From: Brian Banister
Sent: 03 March 2008 08:25
To: Planning.Responses
Subject: RE: Planning Consultation on: SL/11/08/

APPLICATION NO:	SL/11/08/
Registered:	25-FEB-08
Site Address:	Church House Church Hill Slindon
Grid Reference:	496182-108333
Category:	Plan Applicat'n
Description of Works:	To convert the double garage into a guest bedroom with en-suite shower facilities. External of building to remain unchanged.

DRAWING TITLE
PROPOSED PLAN
& ELEVATIONS

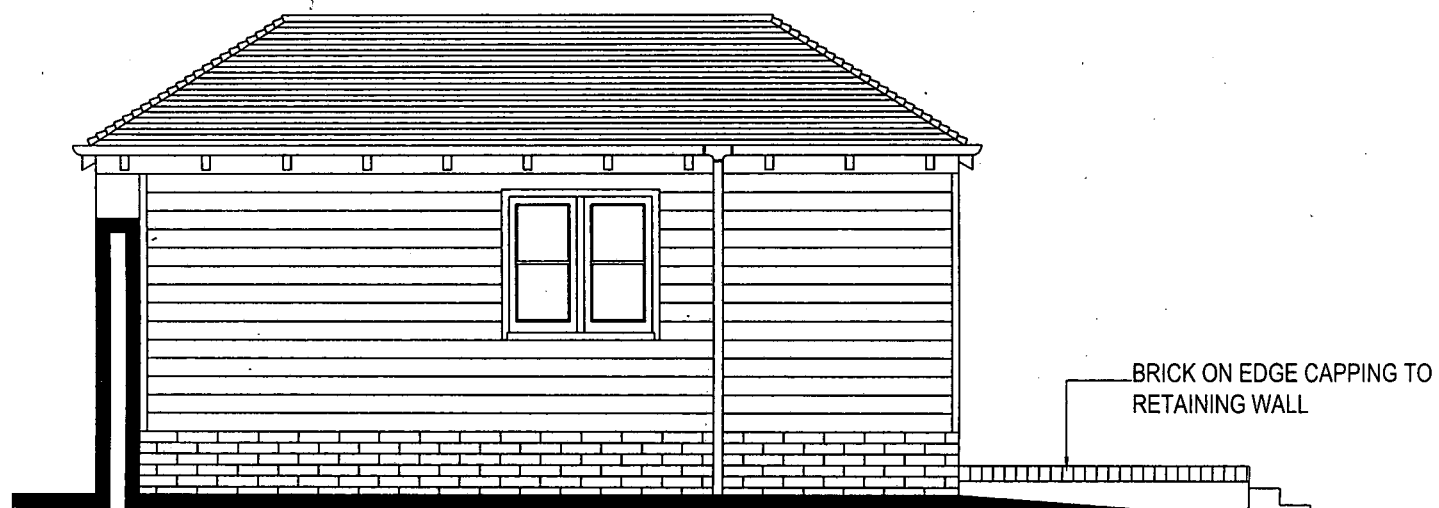
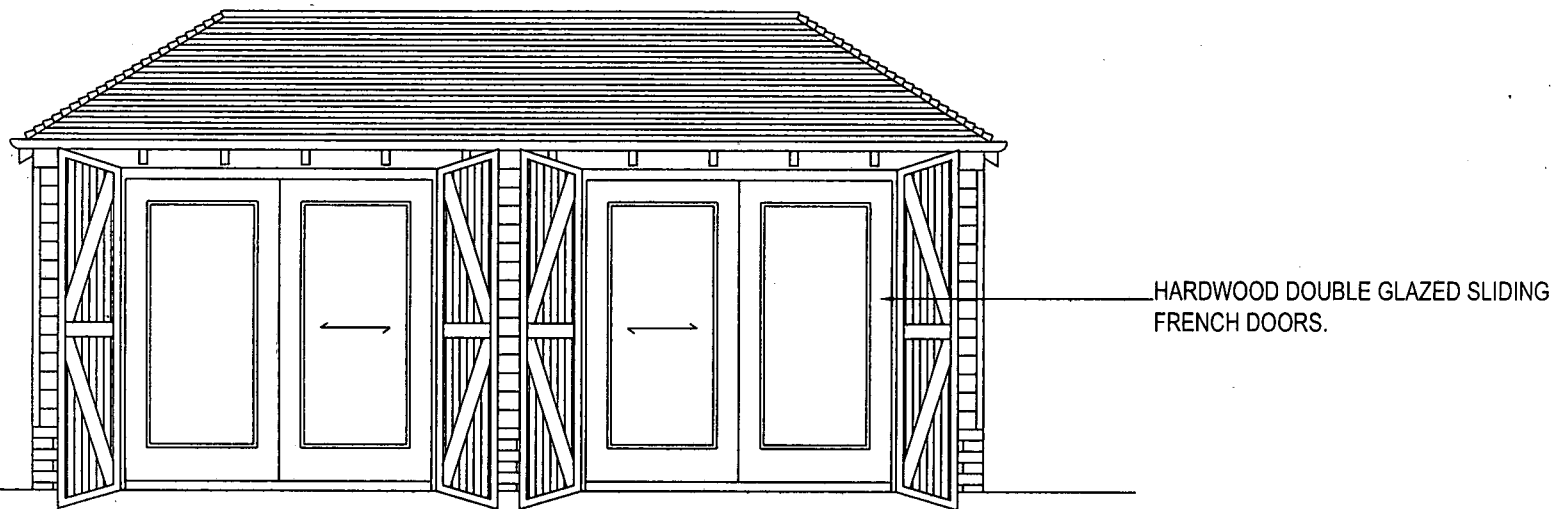
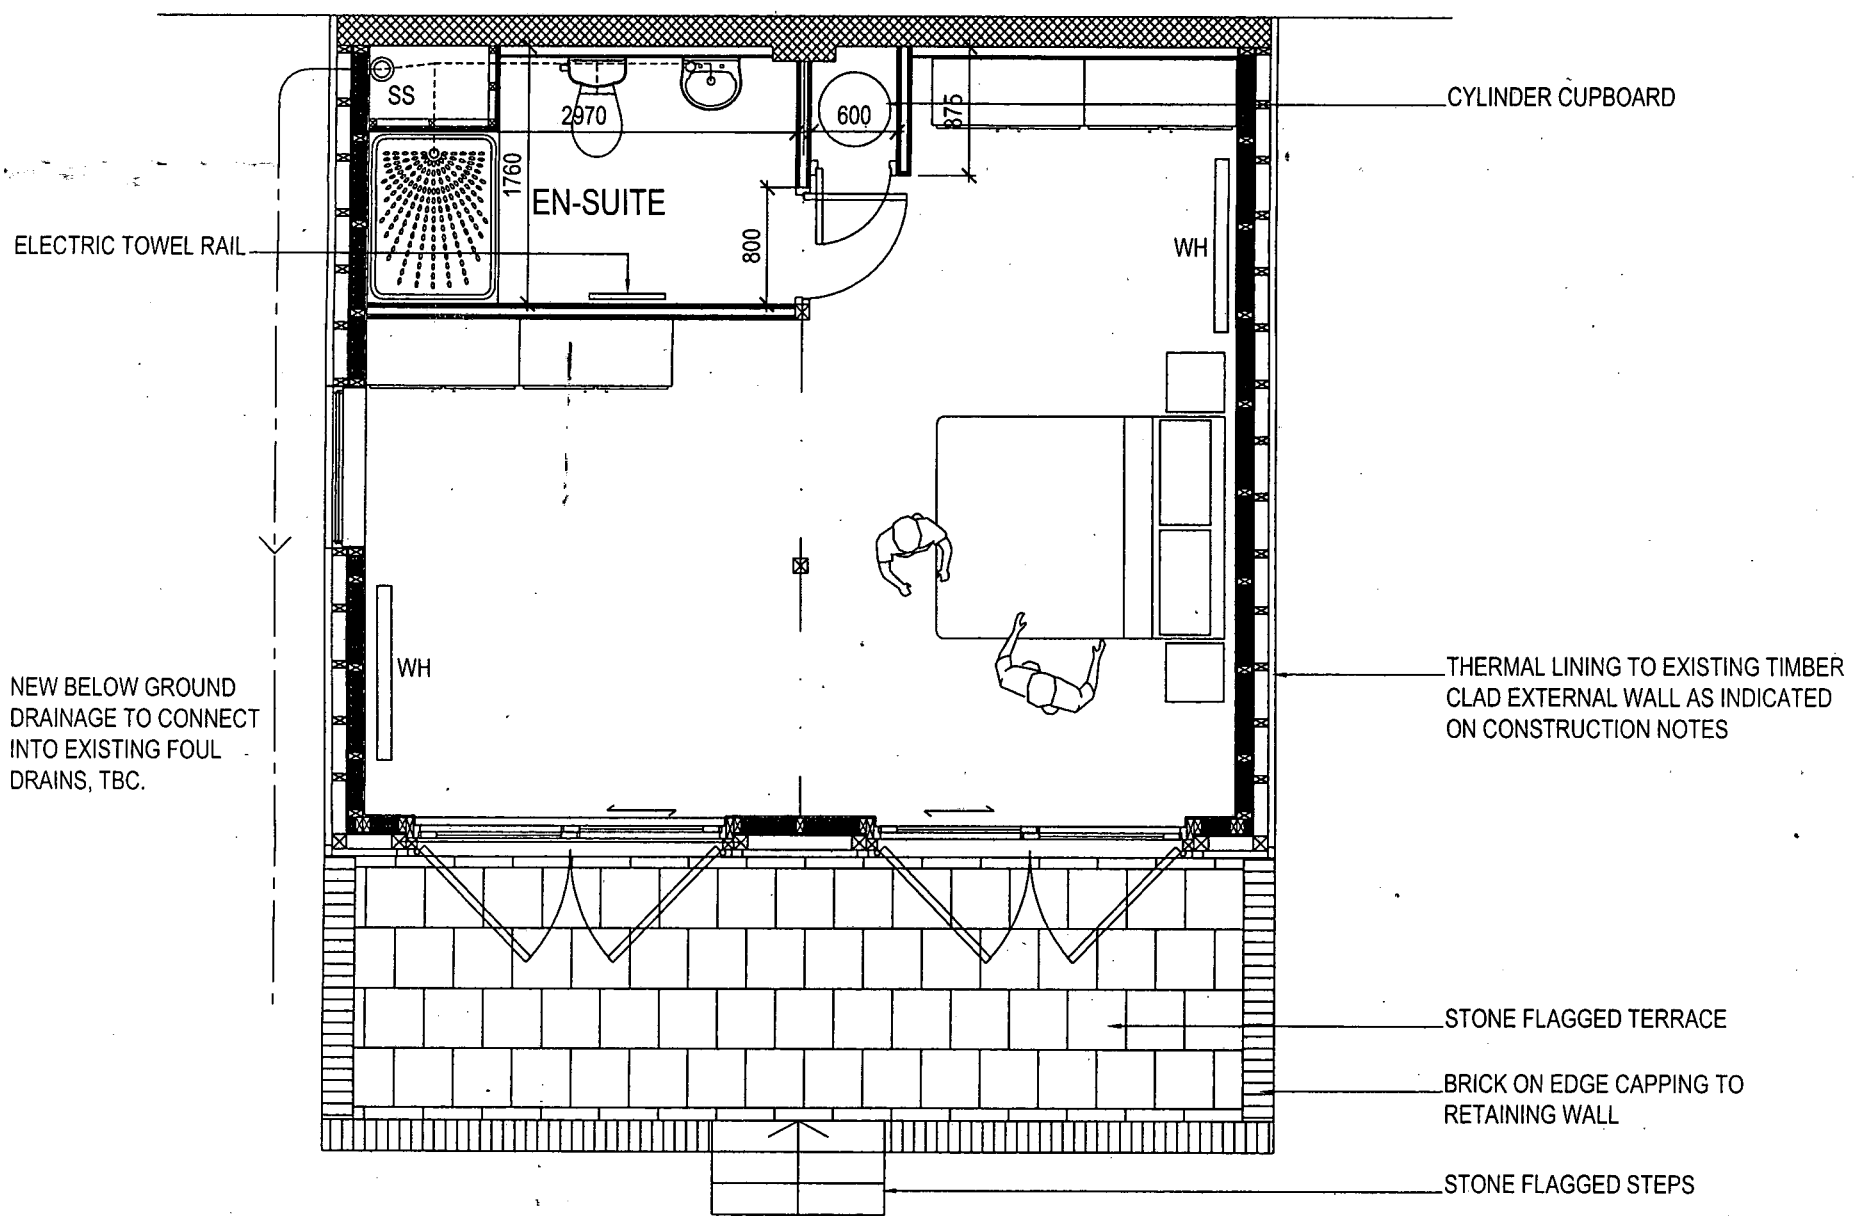
There will be no adverse effect on the character or appearance of the Conservation Area.
 All new external joinery should be stained or painted to match the colour of the external weatherboarding.
